**Ducy Stables and Riding Academy, AL-19-016**

Please accept the following comments from El Paso County Public Health regarding the project referenced above:

PCD FILE Nos PPR-19-027 and AL 19-016

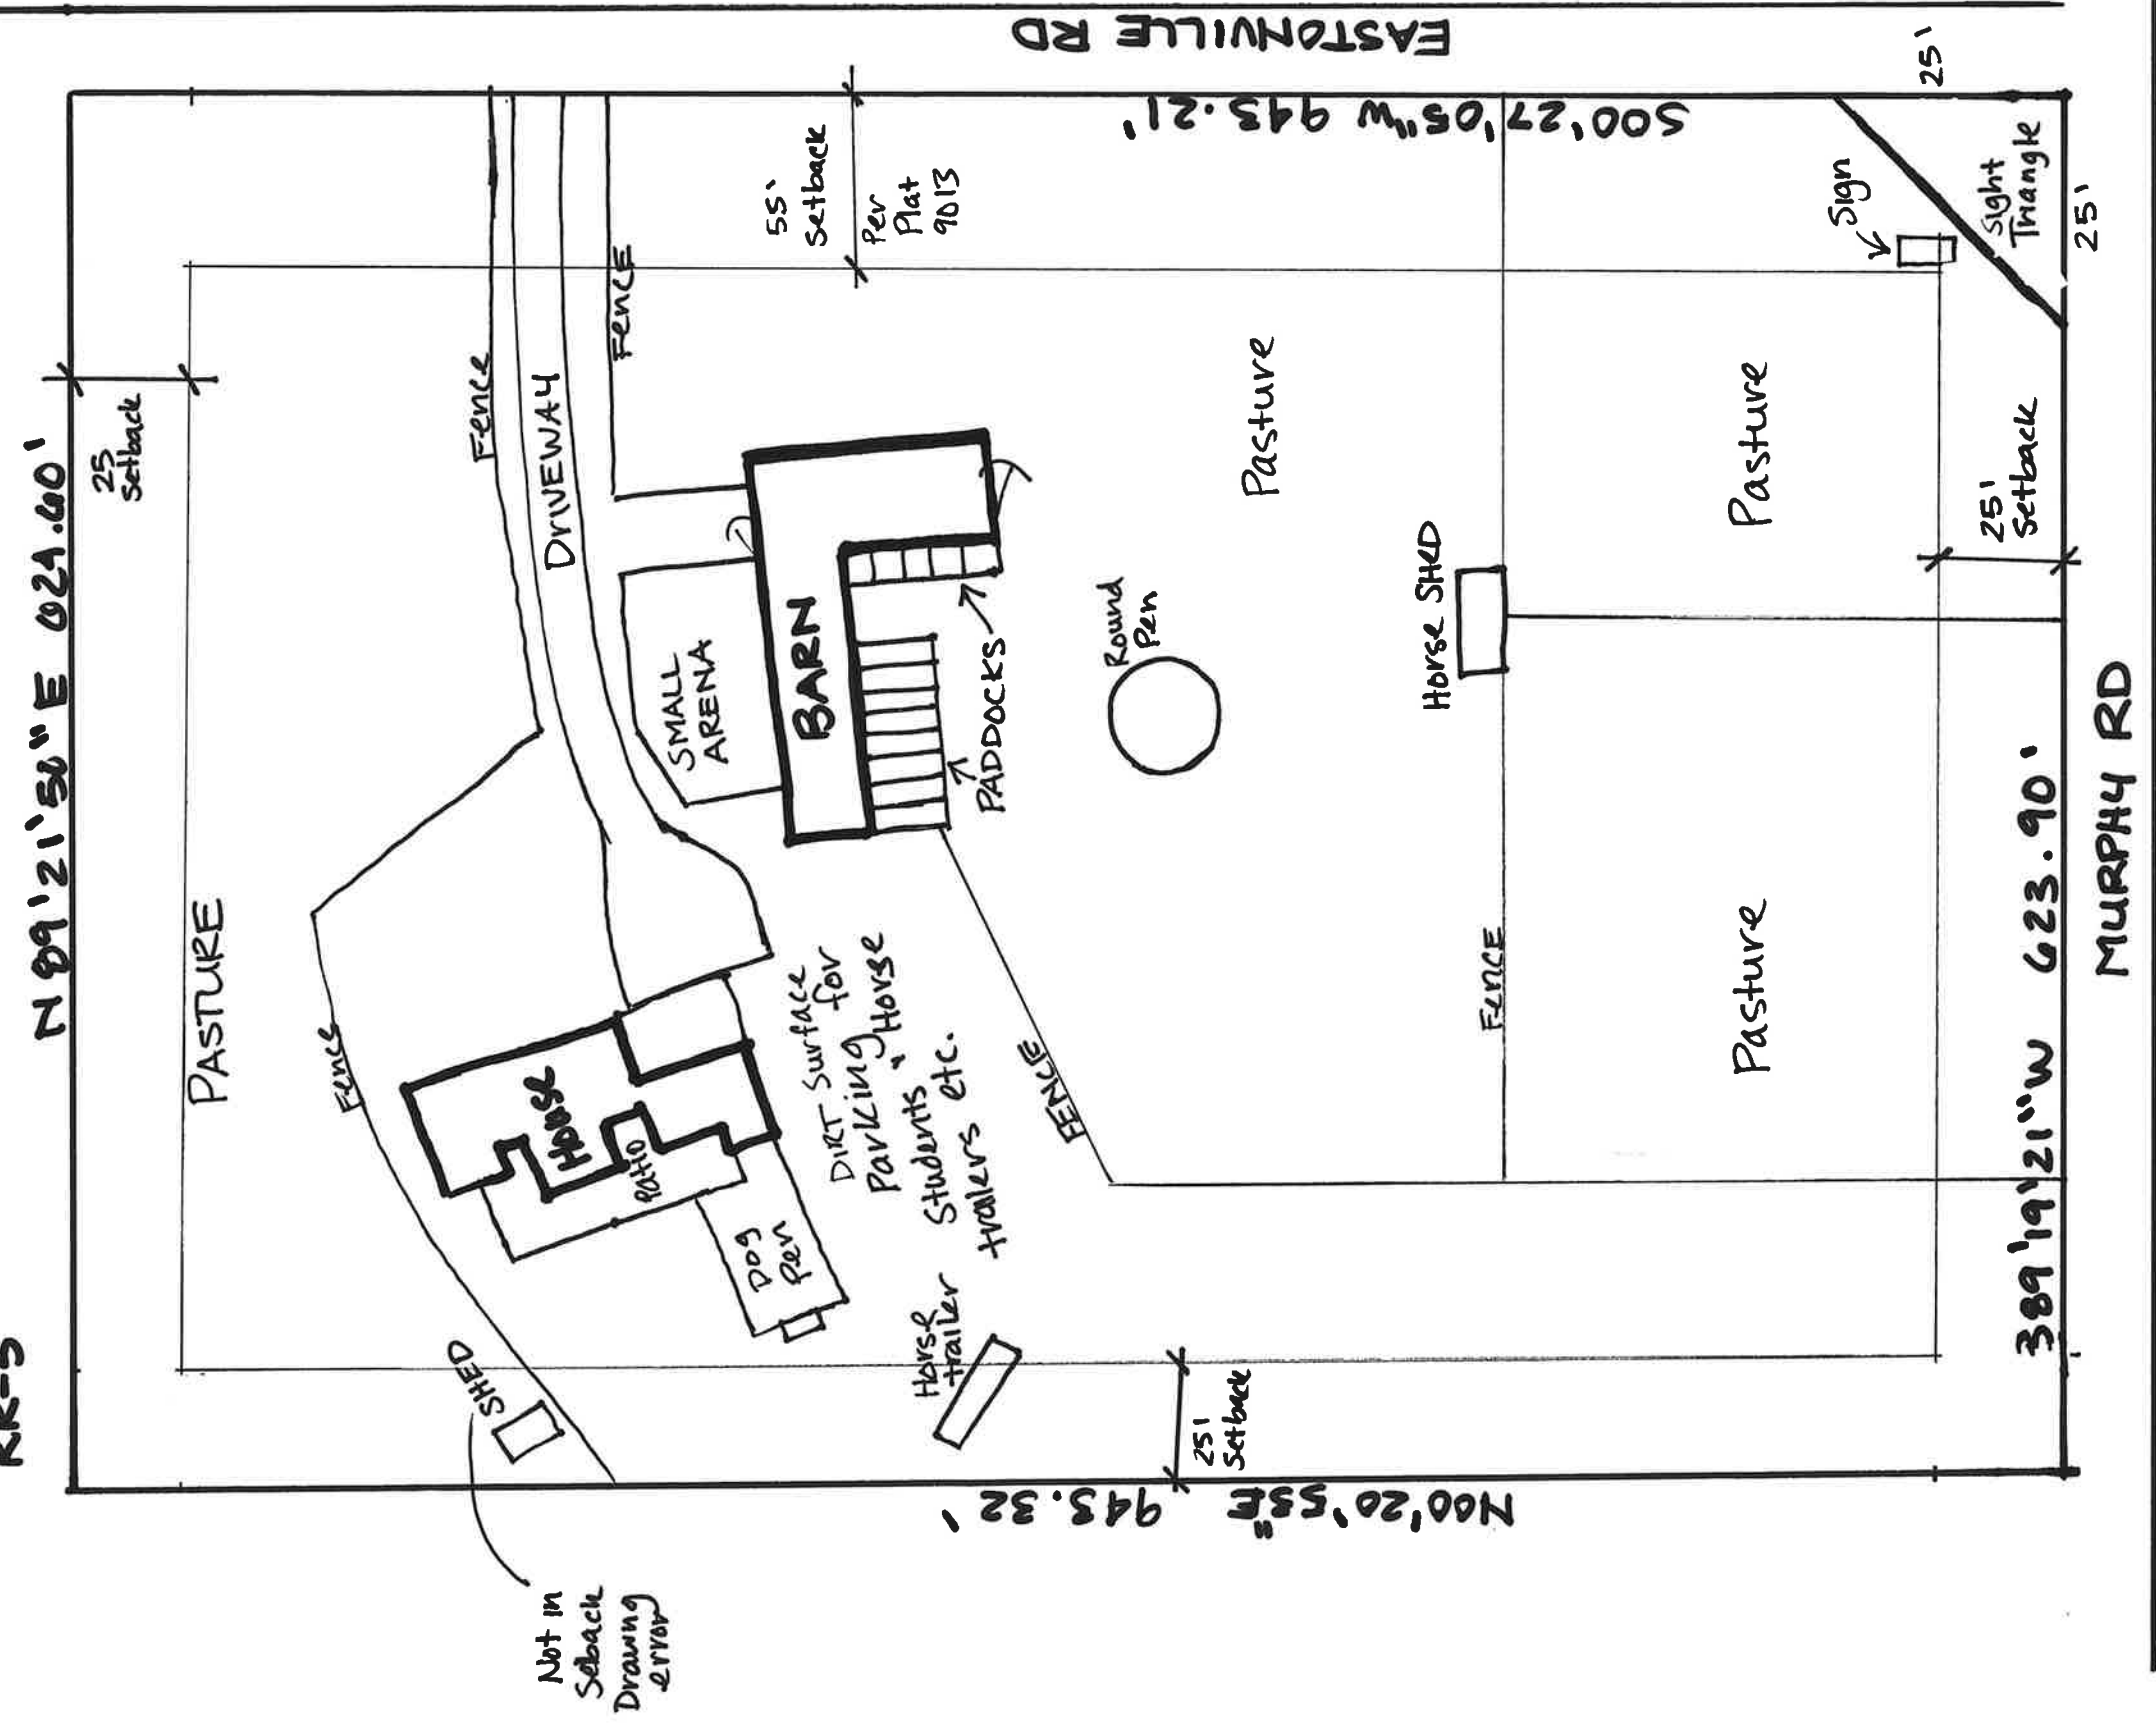
- Restroom facilities were not addressed for customers and employees in the submittal. If the existing OWTS that is connected to the house and barn is planned for customer use, then a professional engineer must evaluate the OWTS for the anticipated wastewater flow increase. The evaluation must be submitted to El Paso County Public Health for review and approval.

- Note: Portable toilets are approved for temporary use only.
- Please assure all components of the OWTS are located and protected from vehicular traffic, livestock and other means of compaction. A secondary site on the property must be preserved for the possibility of a repair, addition, or replacement of the existing soil treatment area. Fencing is preferred but other area identification methods accomplishing the same goal are approved.
